Our ref: RA/2015/132060/03-L01
Your ref: Feeder 9
Our ID: 10031562
Date: 28 September 2015

RELEVANT REPRESENTATION SUMMARY

A REPLACEMENT HIGH-PRESSURE GAS PIPELINE WITHIN A BORED TUNNEL BENEATH THE HUMBER ESTUARY AND ASSOCIATED DEVELOPMENT, INCLUDING A CONNECTING PIPELINE, MINOR MODIFICATIONS TO PAULL ABOVE GROUND INSTALLATION AND ASSOCIATED TEMPORARY LAY DOWN, WORKING AND MITIGATION AREAS. FROM PAULL, EAST RIDING OF YORKSHIRE TO GOXHILL, NORTH LINCOLNSHIRE.

RIVER HUMBER GAS PIPELINE REPLACEMENT PROJECT		
INDICATIVE PAULL SITE LAYOUT FIGURE 2.4 B		
REFERENCE		
DRAWN	CHECKED	APPROVED
JN	KB	NH
SCALE	ORIG SIZE	SHEET
1 : 1000	A1	1 of 1
DATE		REVISION
12 OCT 15		03

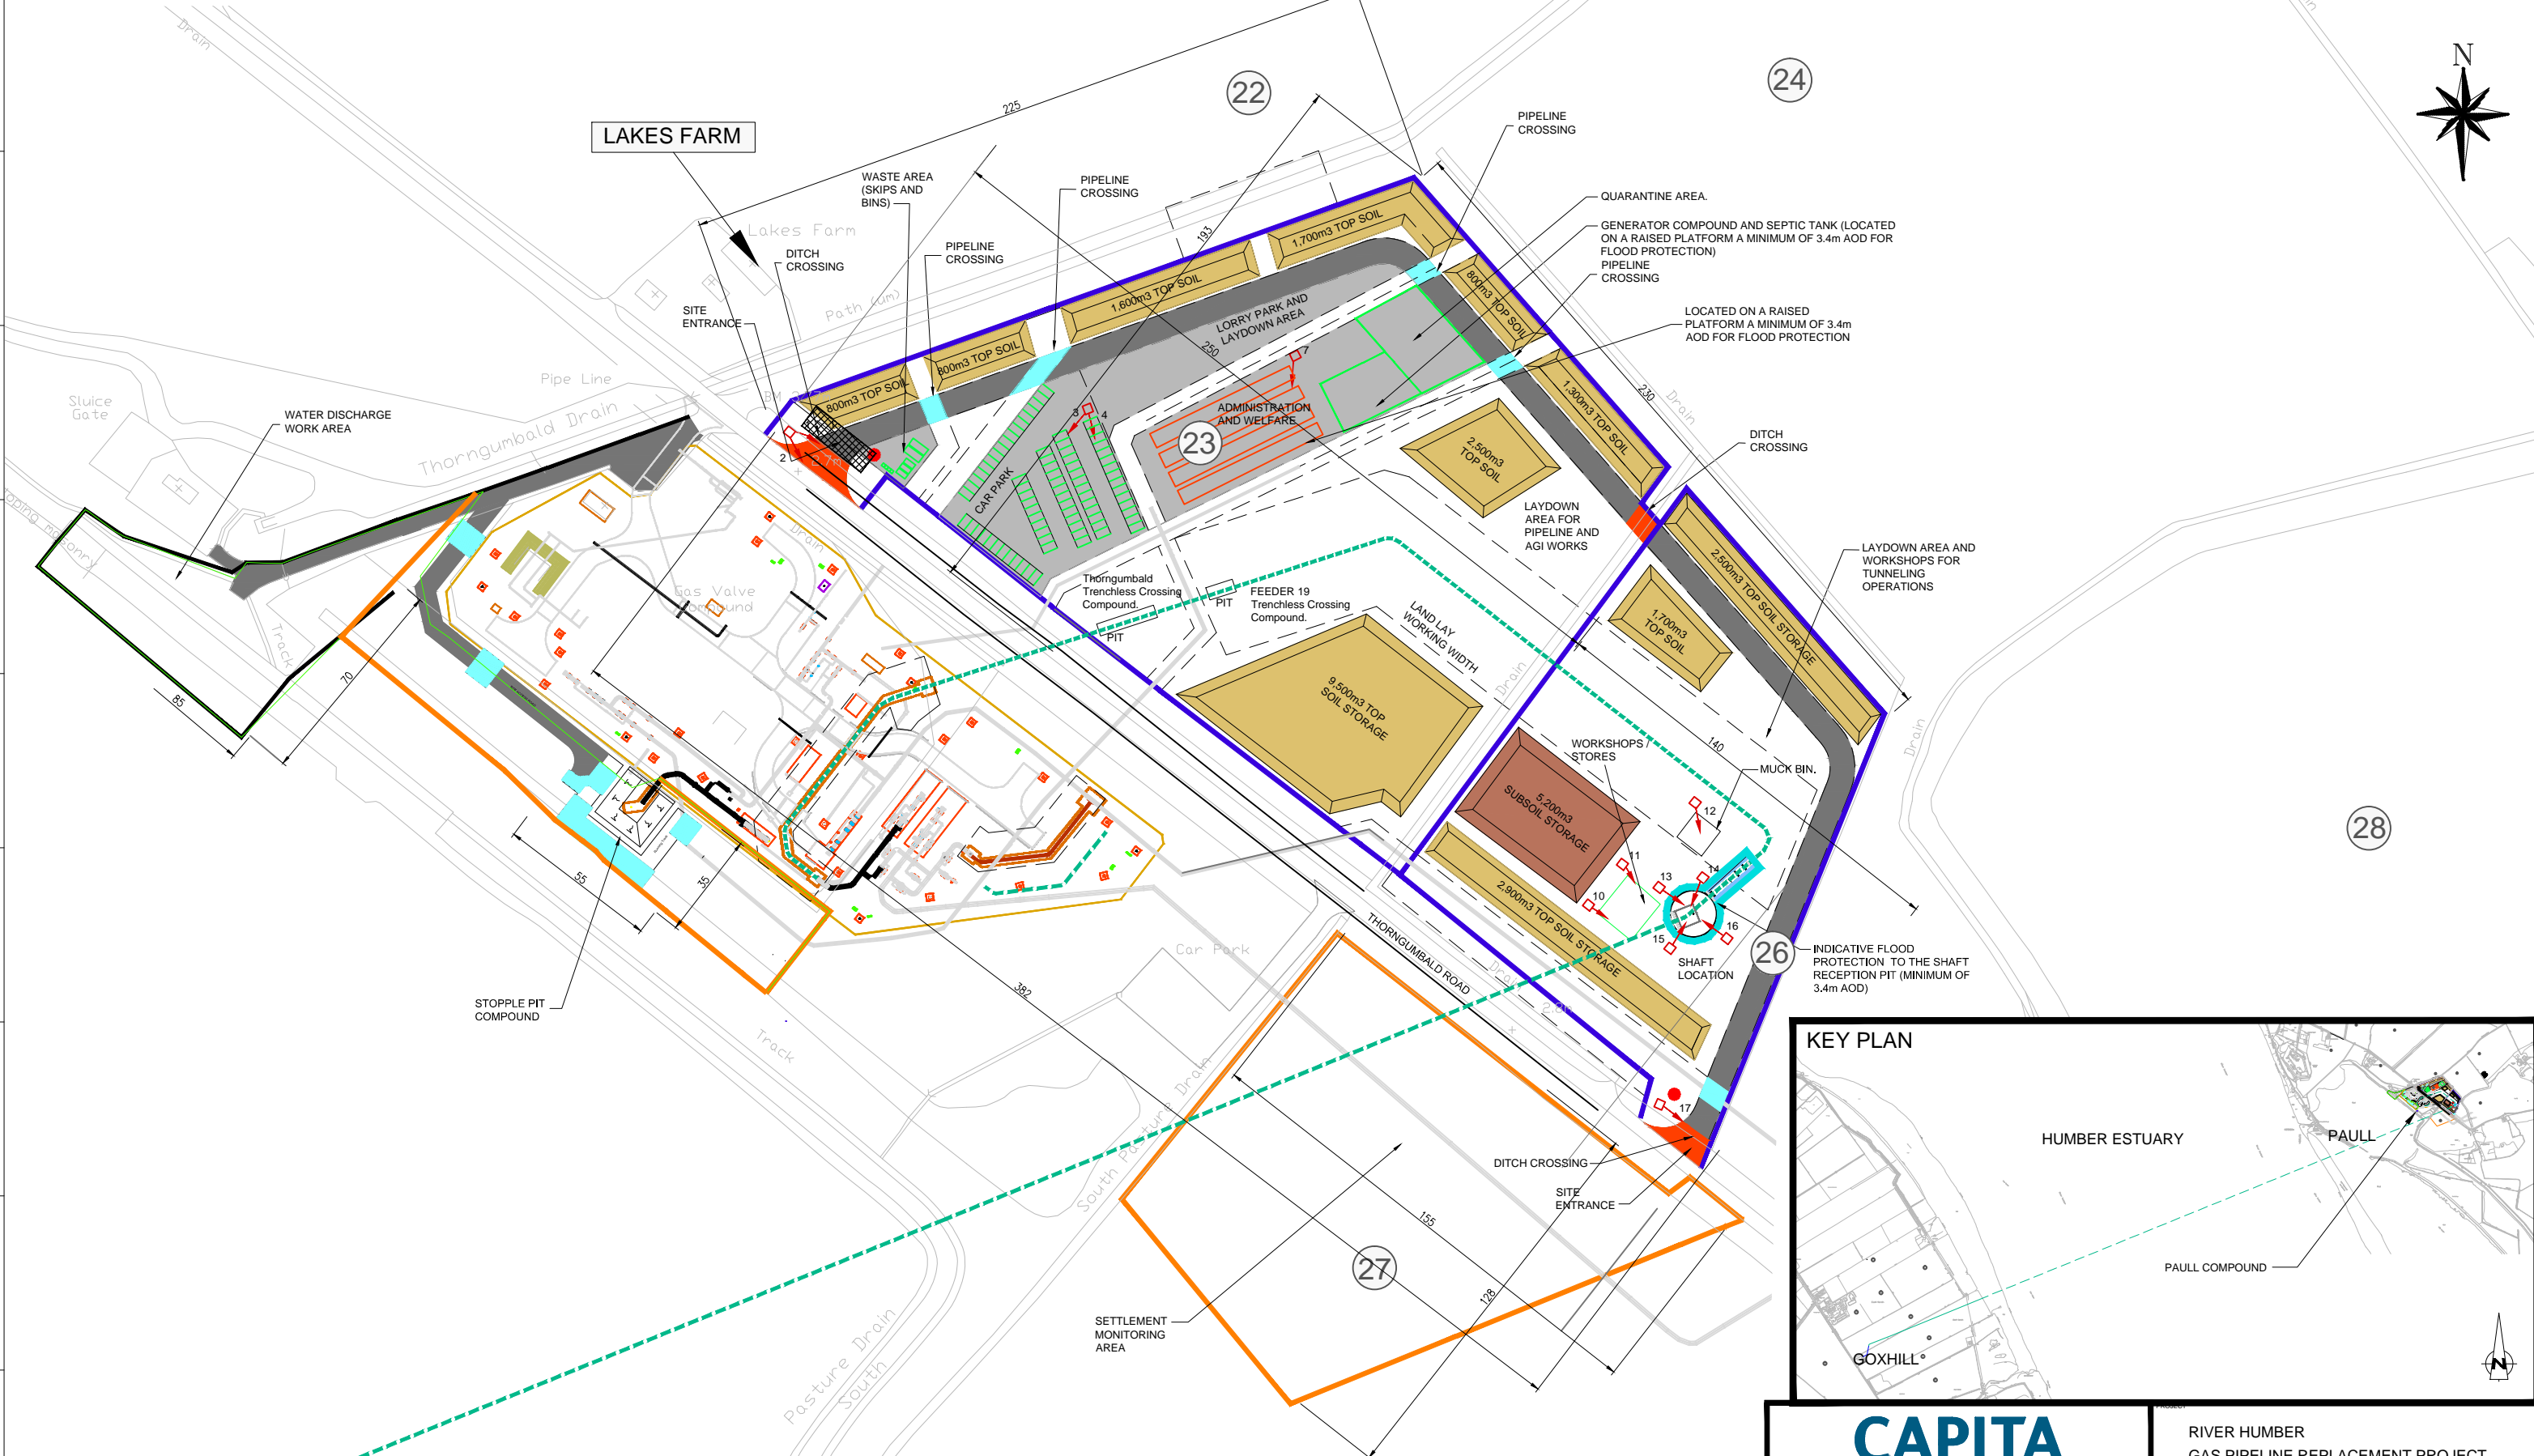
- 7) The FRA identifies that flood depths from fluvial flooding will be increased as a result of the development. However, insufficient assessment has been made of the potential receptors for this;
- 8) The 'Indicative Paull Site Layout' shows an area denoted as the 'water discharge work area' which appears to coincide with the existing flood defence and Thorngumbald Pumping Station outfall. More detail is requested;
- 9) Any mitigation measures deemed necessary in a suitably updated and approved FRA will need to be secured in the DCO.
